Submissions Report

Mixed-Use Development with In-Fill Affordable Housing

2-6 Pilgrim Avenue and 11-13 Albert Road, Strathfield

SSD-80432461

PLENUM DETAILS

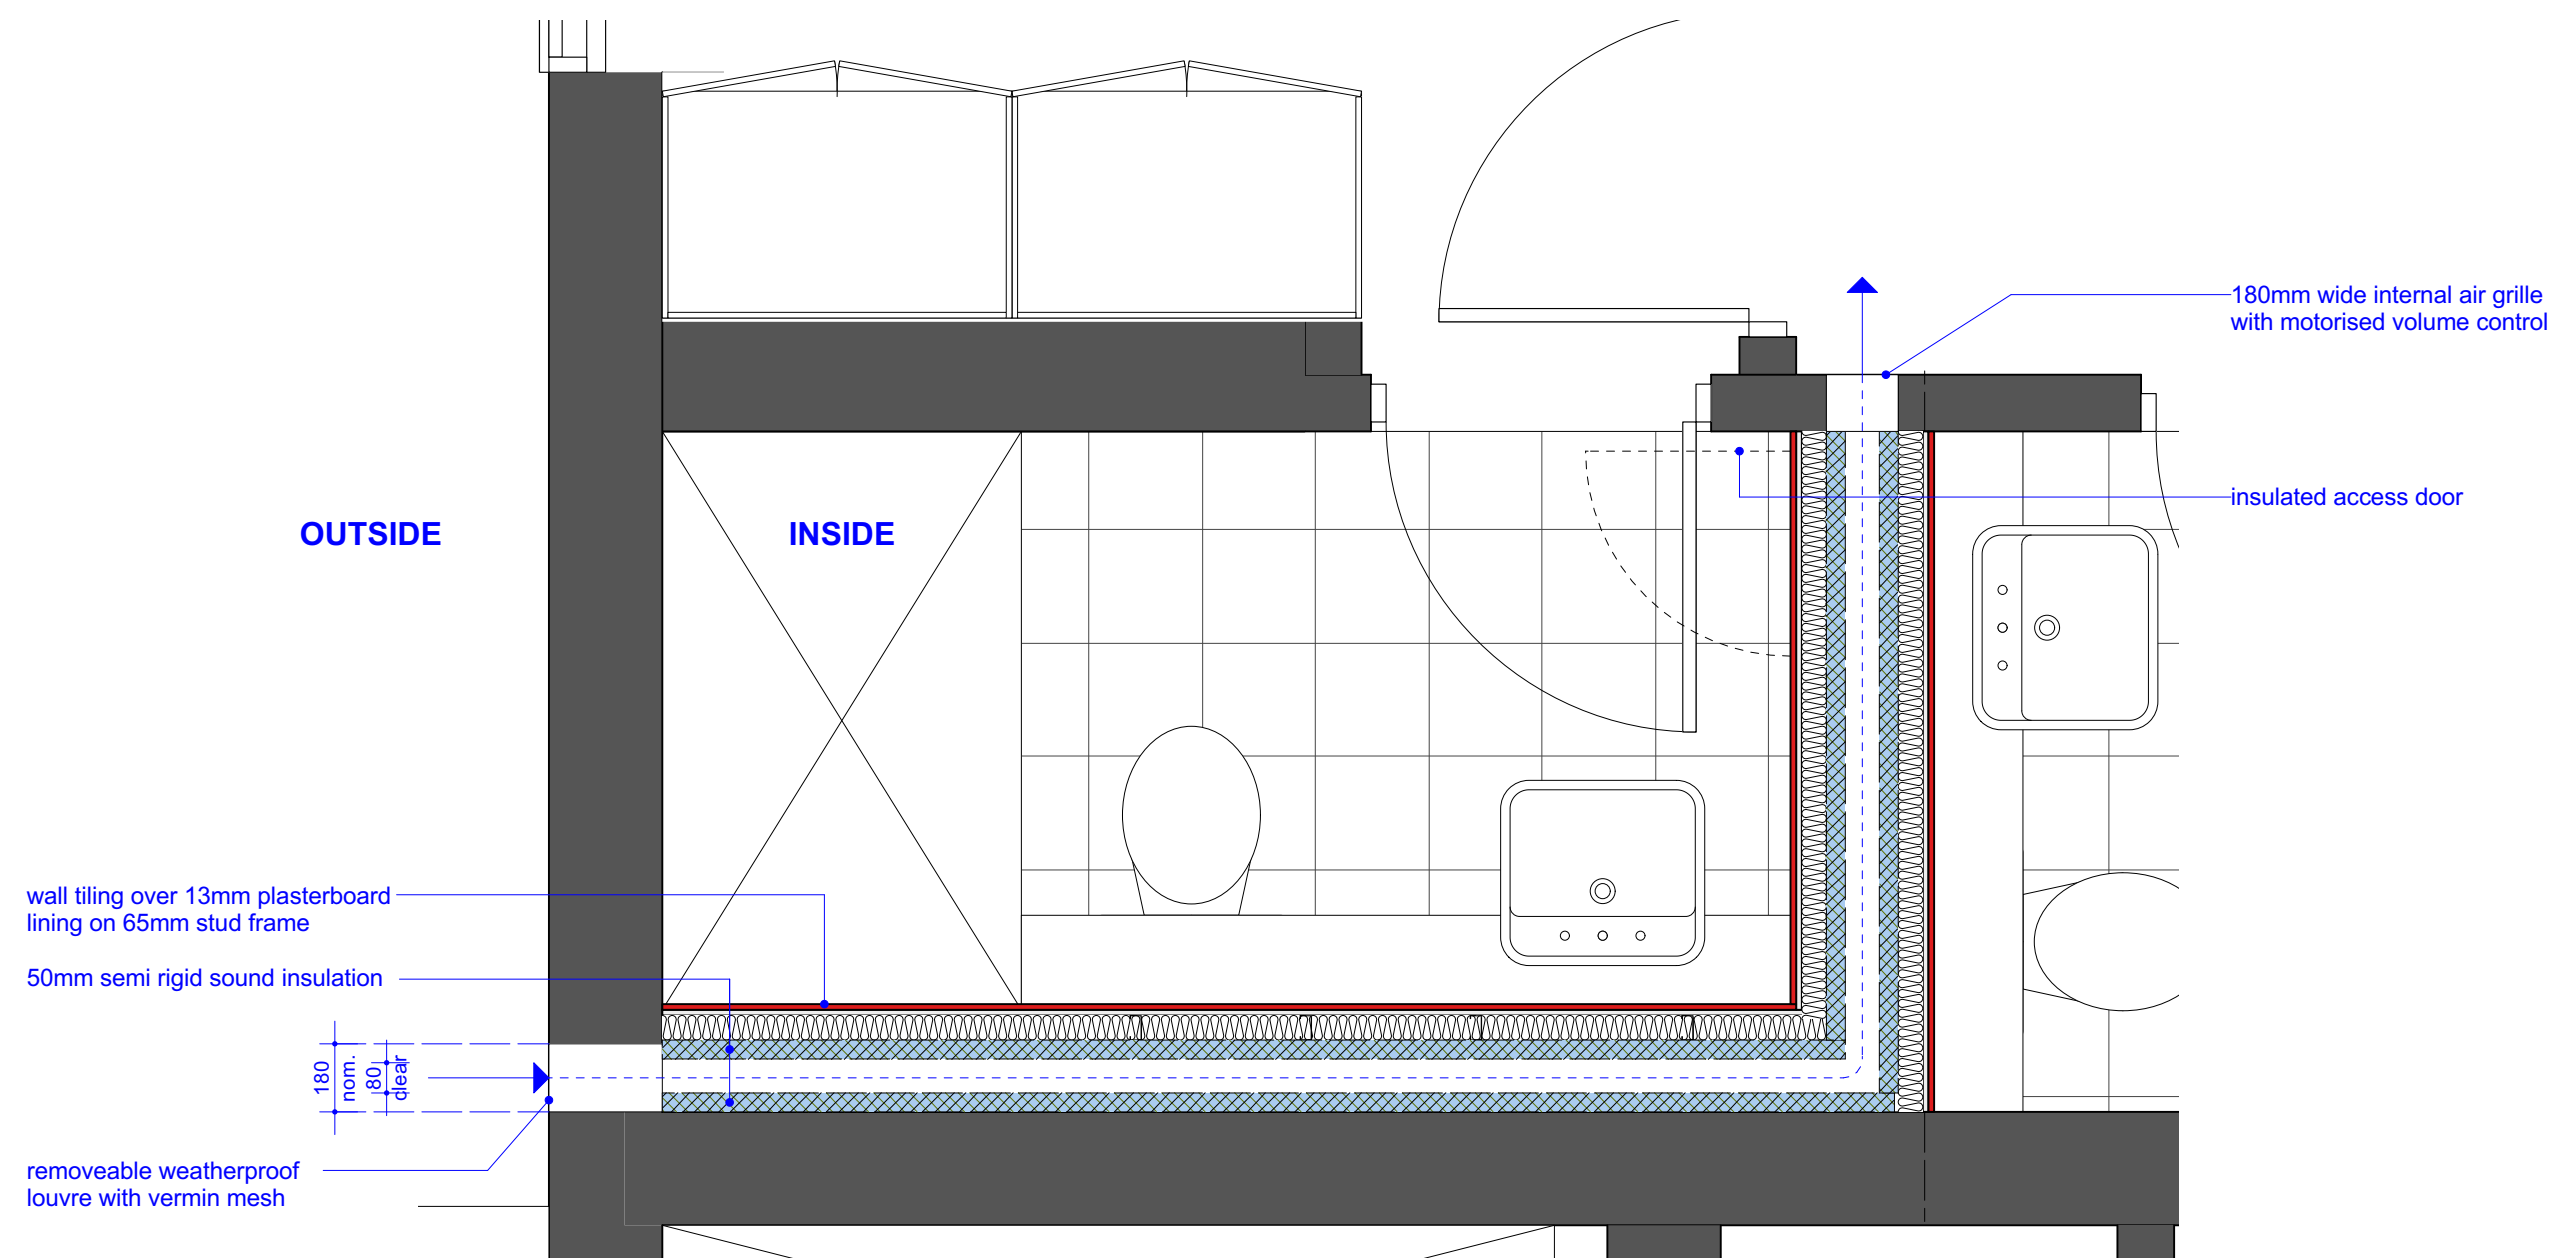
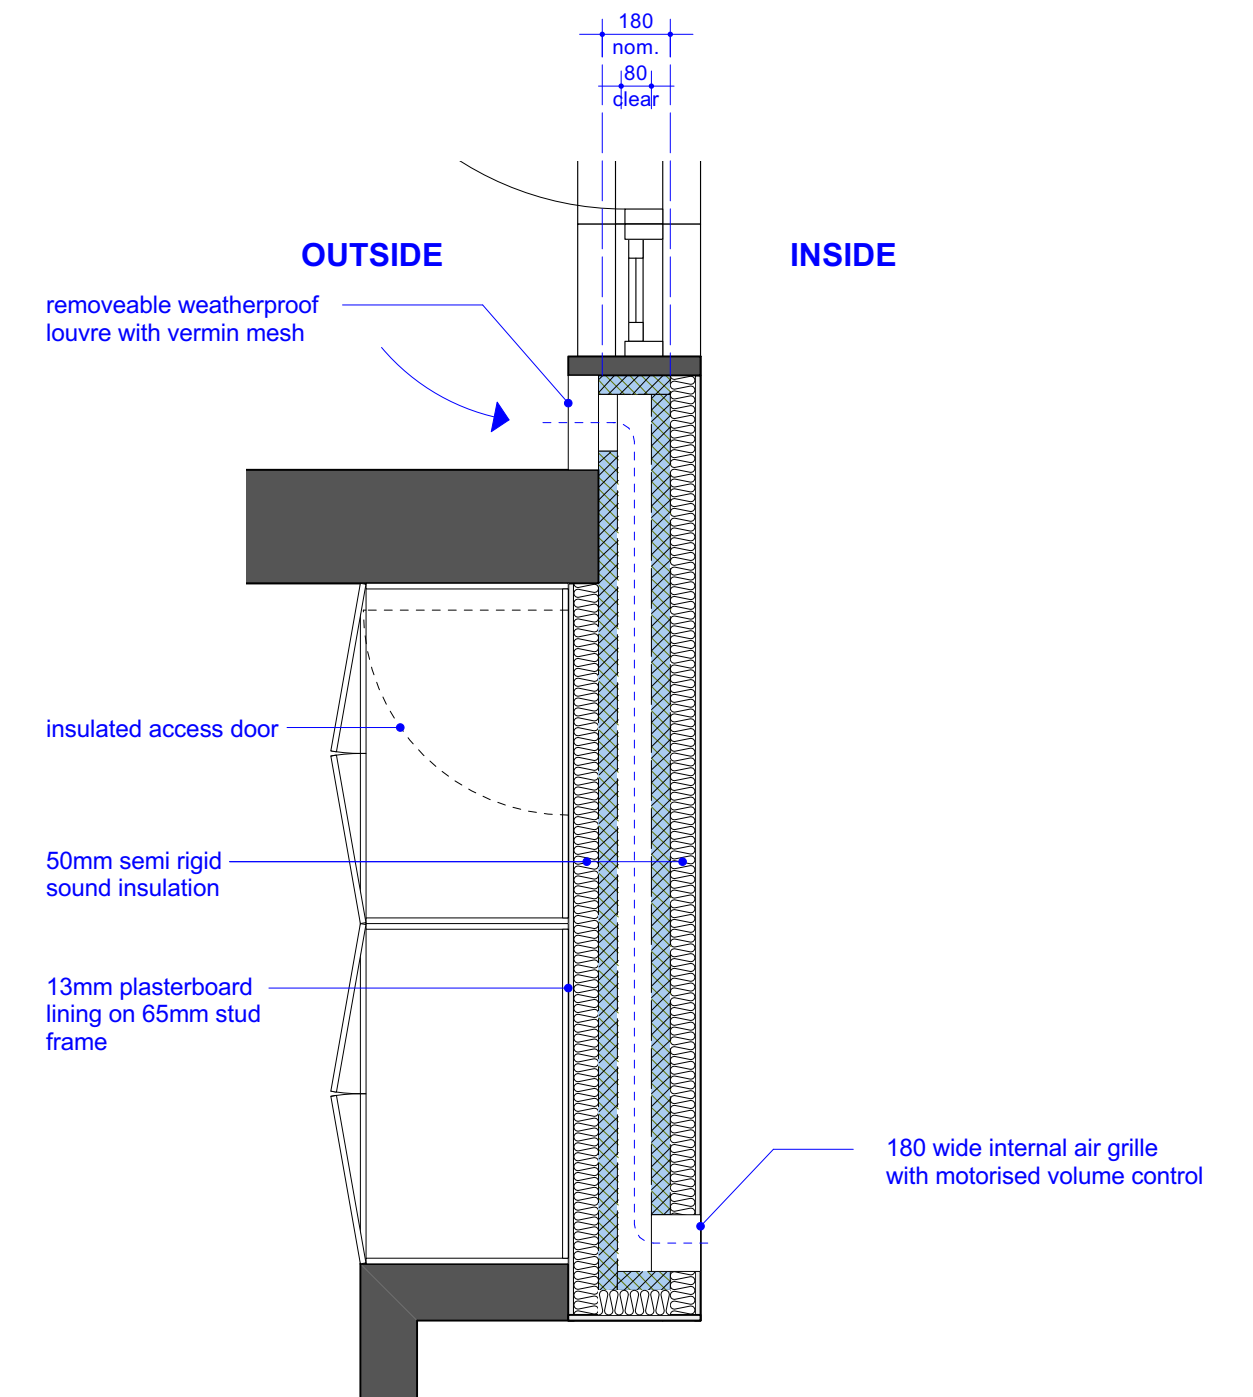
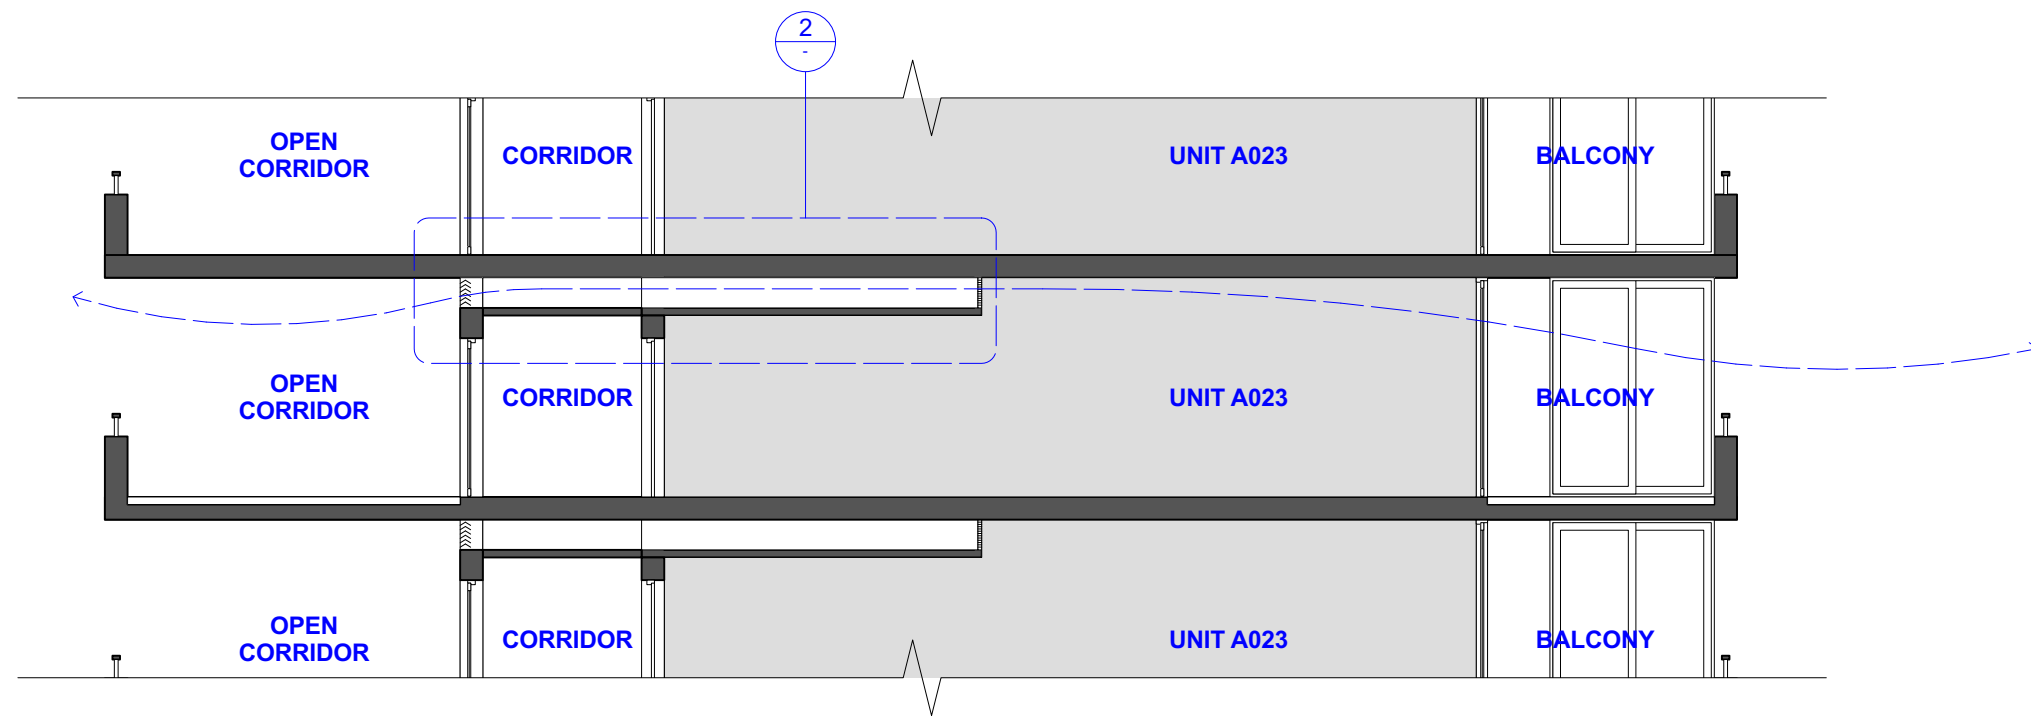
Matter Raised	Applicant Response
• Council does not support cross-ventilation via plenums. It is strongly recommended that apartments are converted (where possible) into 2-storey 3+ bedroom units in order to achieve the following: - Cross-ventilation (single aspect 2-storey is considered cross-ventilated in the ADG - Increase the % of 3-bedders. 7% is not close enough to a minimum 10% in the ADG, Homebush TOD's 20% mandate and Strathfield councils own strategic plan.	<i>Guideline.</i> Refer to DA0652.1 of the updated Architectural Drawings (Appendix B) for further details. The use of plenums to achieve natural and cross ventilation in high rise developments is a widely accepted industry practice supported by both local government and the Land & Environment Court. Most developments of the scale of this project rely on some form of plenum for a limited number of units. In this project, of the 96 apartments within the first nine storeys of the development only three (3) units, Units A 013, A 023 & A033, (2%) rely on the use of plenums for natural and cross ventilation to comply with ADG minimum requirement that 60% of units be naturally cross-ventilated. That is, the use of plenums has been limited to a very small proportion of units and applied only where necessary. A further nine (9) units (the units facing Albert Road) incorporate a combination of operable windows and plenums to achieve cross ventilation in all conditions. The use of plenums is a widely accepted mechanism for delivering natural ventilation to high density urban developments. Windtech, the ventilation consultants on the project, have reviewed the proposed unit configuration and plenum design and confirmed that the plenums will provide sufficient ventilation to meet the objectives of the ADG. The use of plenums has been limited to a small proportion of units and applied only where necessary, ensuring full compliance while preserving the integrity of the overall apartment mix. Multiple detailed wind tunnel studies have been undertaken to verify the effectiveness of horizontal plenums for use as natural cross-ventilation. These studies have confirmed the minimum sizing requirements to ensure their effectiveness as mitigation devices. Previously approved SSD projects which include plenums to achieve cross-ventilation that Windtech has worked on include 136 - 148 New South Head Road, Edgecliff (SSD-77608714) and Hills Showground Precinct East (SSD-62802207). Note that we have proposed the inclusion of horizontal plenums in numerous other SSD and non-SSD projects which are yet to be determined.
